FIRST BAPTIST CHURCH BALCONY AND PARKING ADDITION
SITE PLAN, CONDITIONAL USE REVIEW
FIRST BAPTIST CHURCH, APPLICANT

Portland Planning Board
Portland, Maine

May 12, 1992

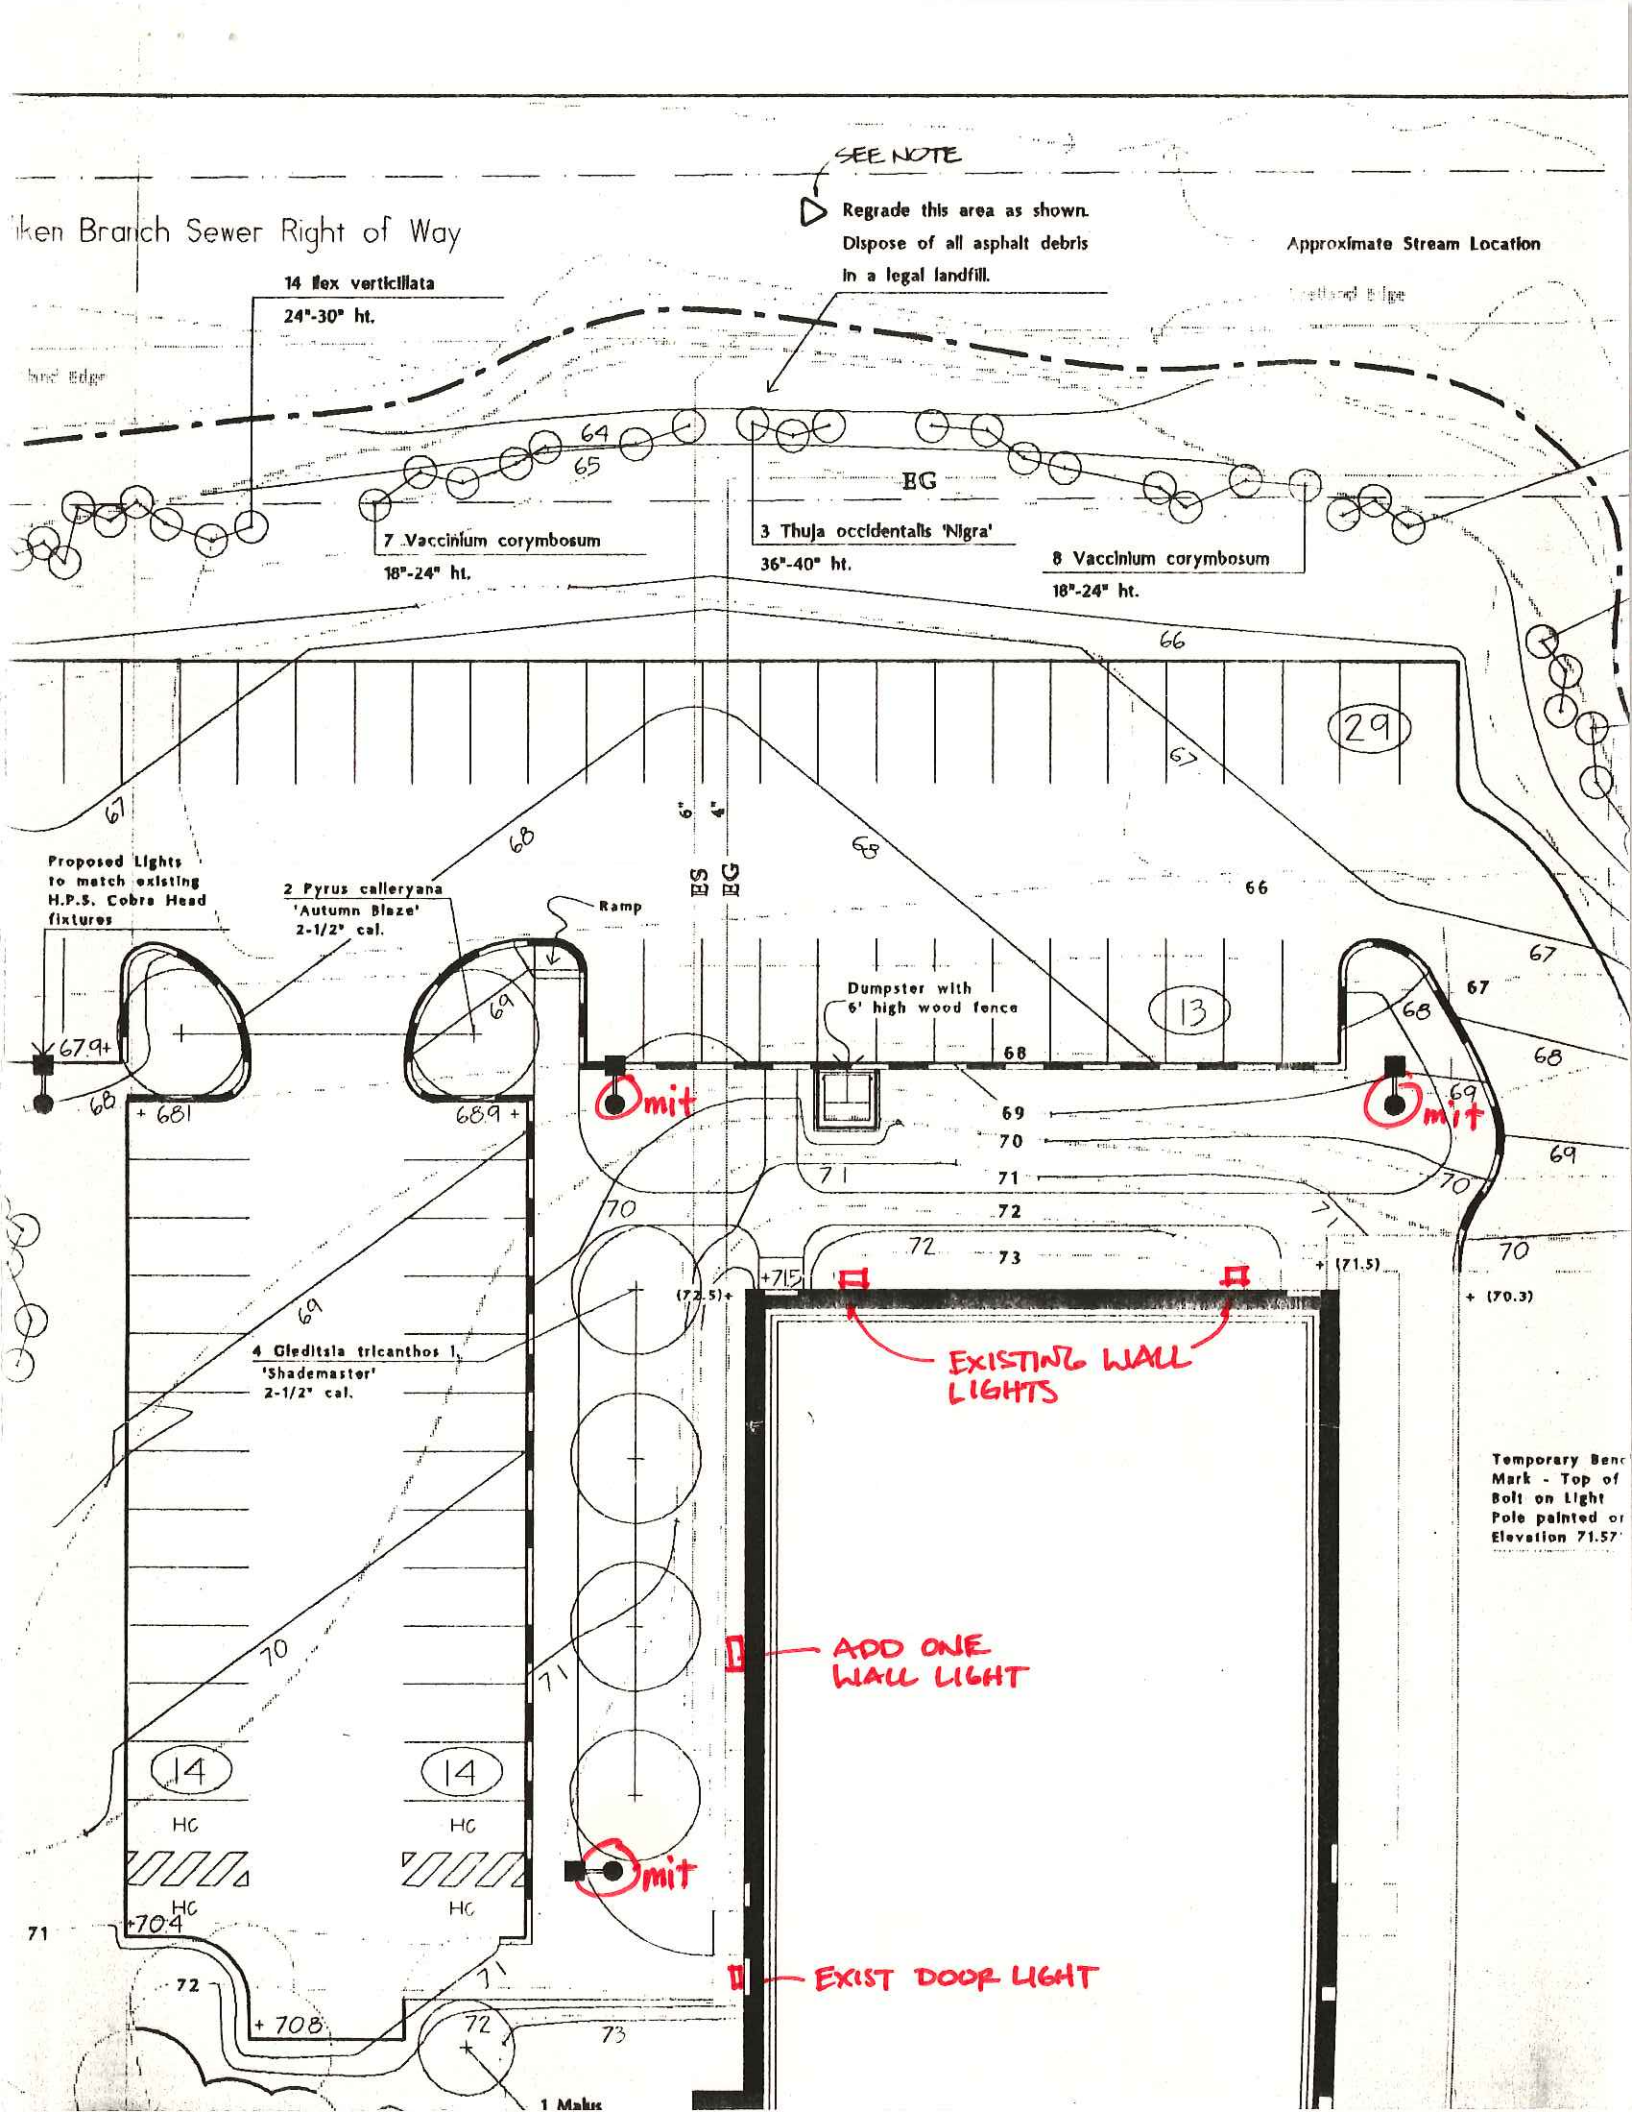
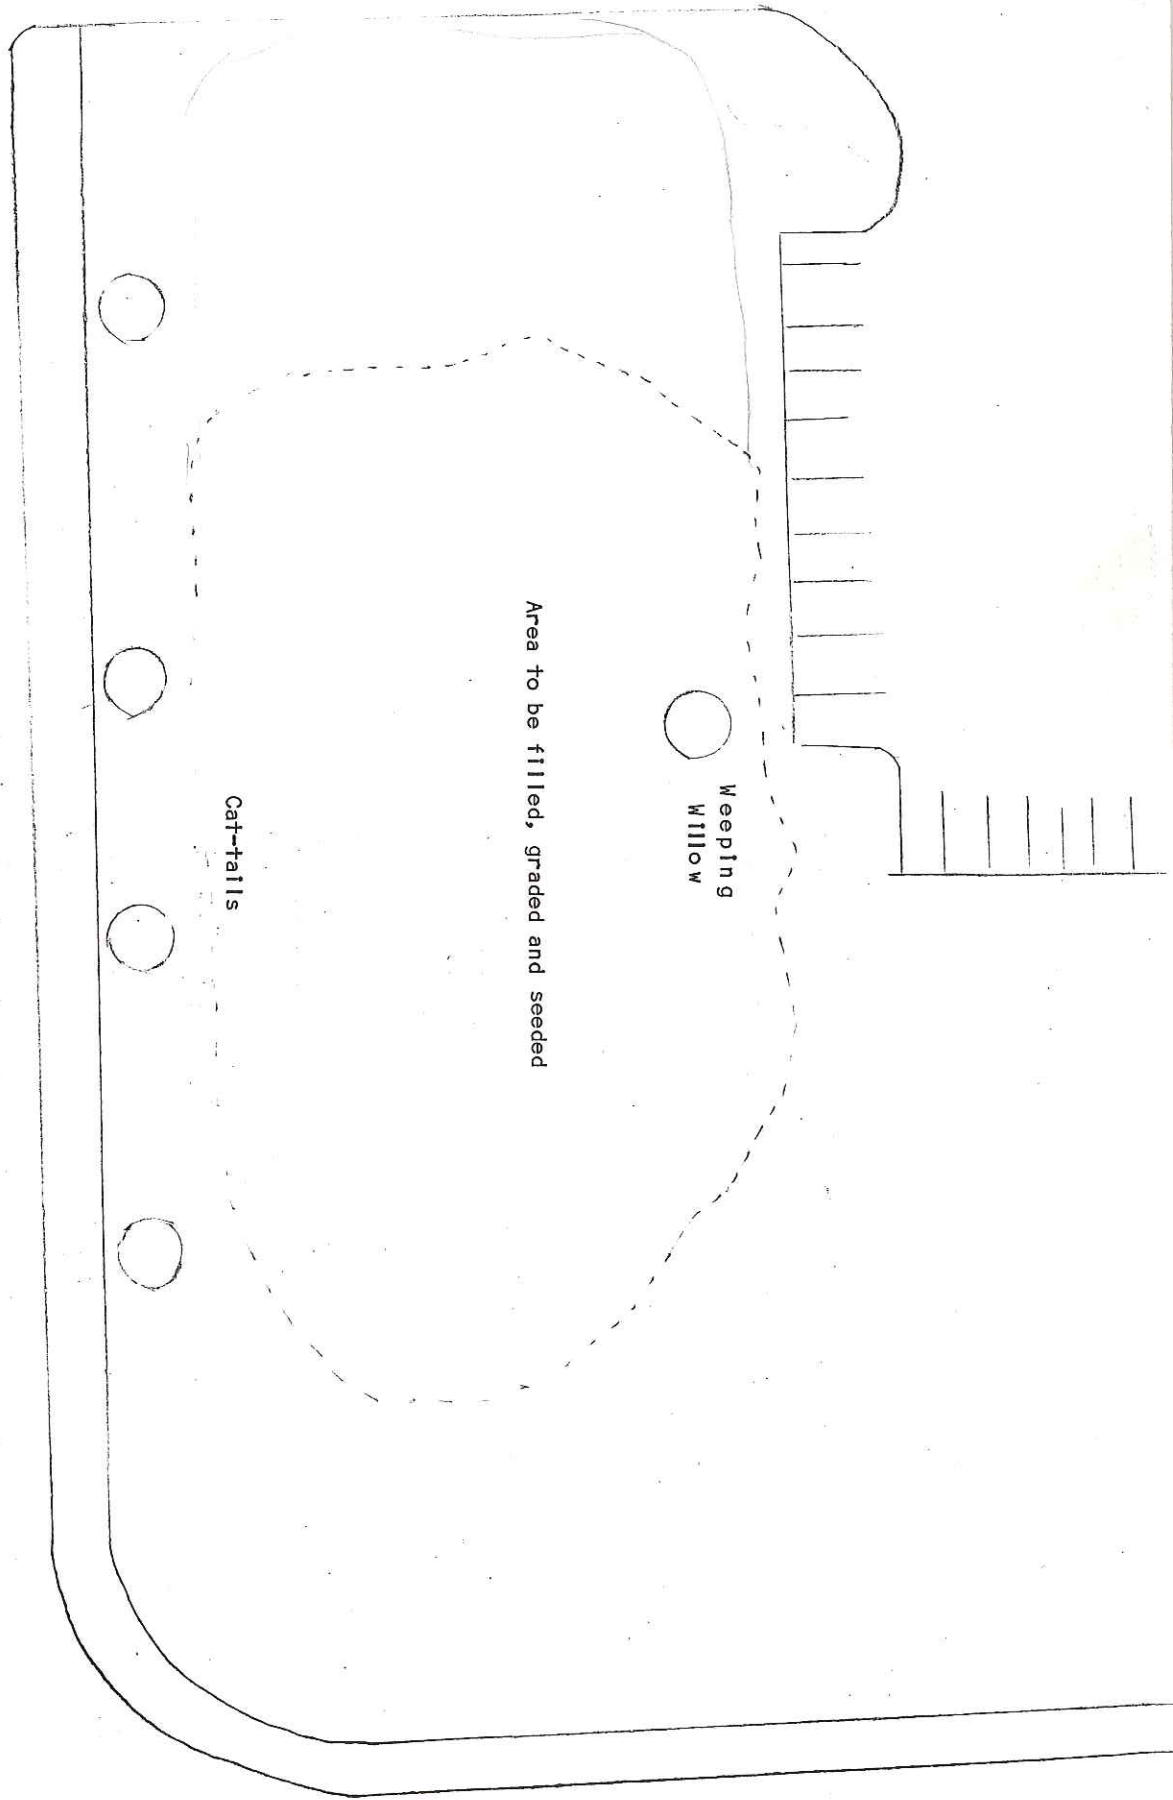
The applicant proposes to landscape the parking area with four "shade master" trees, two Autumn Blaze trees and one floribunda. The areas between the parking lot and wetland areas will be landscaped with 28 Vaccinium Corymbosum, 10 Thuja Occidentalis Nigra and 17 Ilex Verticillata. These plants were chosen by the applicant in consultation with the Department of Environmental Protection, in order to provide a satisfactory buffer between the parking areas and more sensitive wetlands areas. These plantings will serve as a "treatment" of stormwater draining from the parking lot.

Additionally, the applicant intends to make improvements to the Canco/Washington corner of the parcel by regrading, loaming and seeding. All trees will be preserved. A screened dumpster will be placed between the church and parking lot.

Stormwater from the southwest parking lot will be directed through regrading to flow through the added buffer area and into the wetland. Likewise, runoff from the west area of the parking lot will flow into the landscaped areas and into the Fall Brook via the wetland.

The applicant proposes to install five new exterior lights mounted on 25 ft. high poles. The new lights will match the existing which are 150 watt, high pressure sodium cobra head lights. There are five light poles currently in the existing parking lots.
